PAGHAM PARISH COUNCIL

22.10.2015

Planning Ref. P58/15/OUT /251, Pagham Road.

Figure 18 - Proposed Summer Lane/Pagham Road Junction

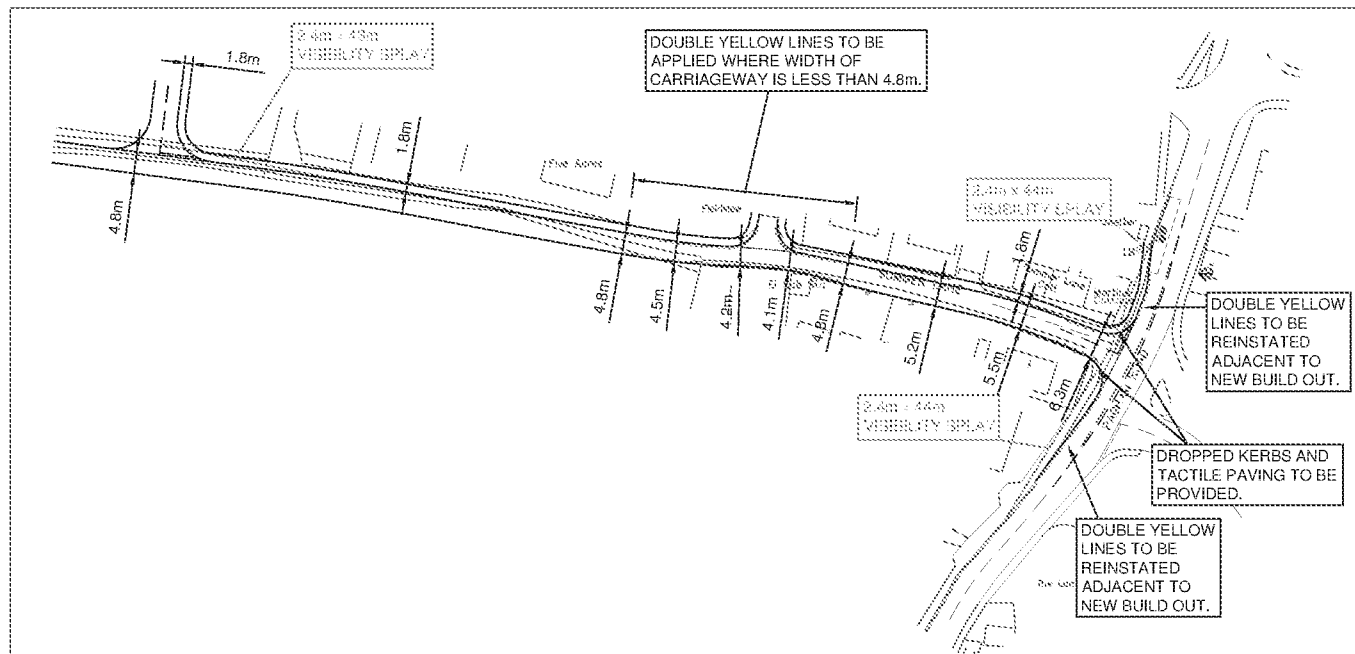
1. Significant improvements in both width, height and density of landscape/translocation buffer to rear of Pagham Road dwellings.
2. Revised layout near proposed Pagham Road access road in order to include compensatory public parking provision.

3. Commitment to provide shared new access road with adjacent development by Hanbury Properties Ltd. This would be covered by condition, as this was to be considered as a conjoined development as promoted by the Pagham Neighbourhood Plan, and was also stipulated by Cabinet Member that the resultant two access roads (inc. Summer Lane) would provide for efficient emergency Vehicle access/egress with no encumbrance.
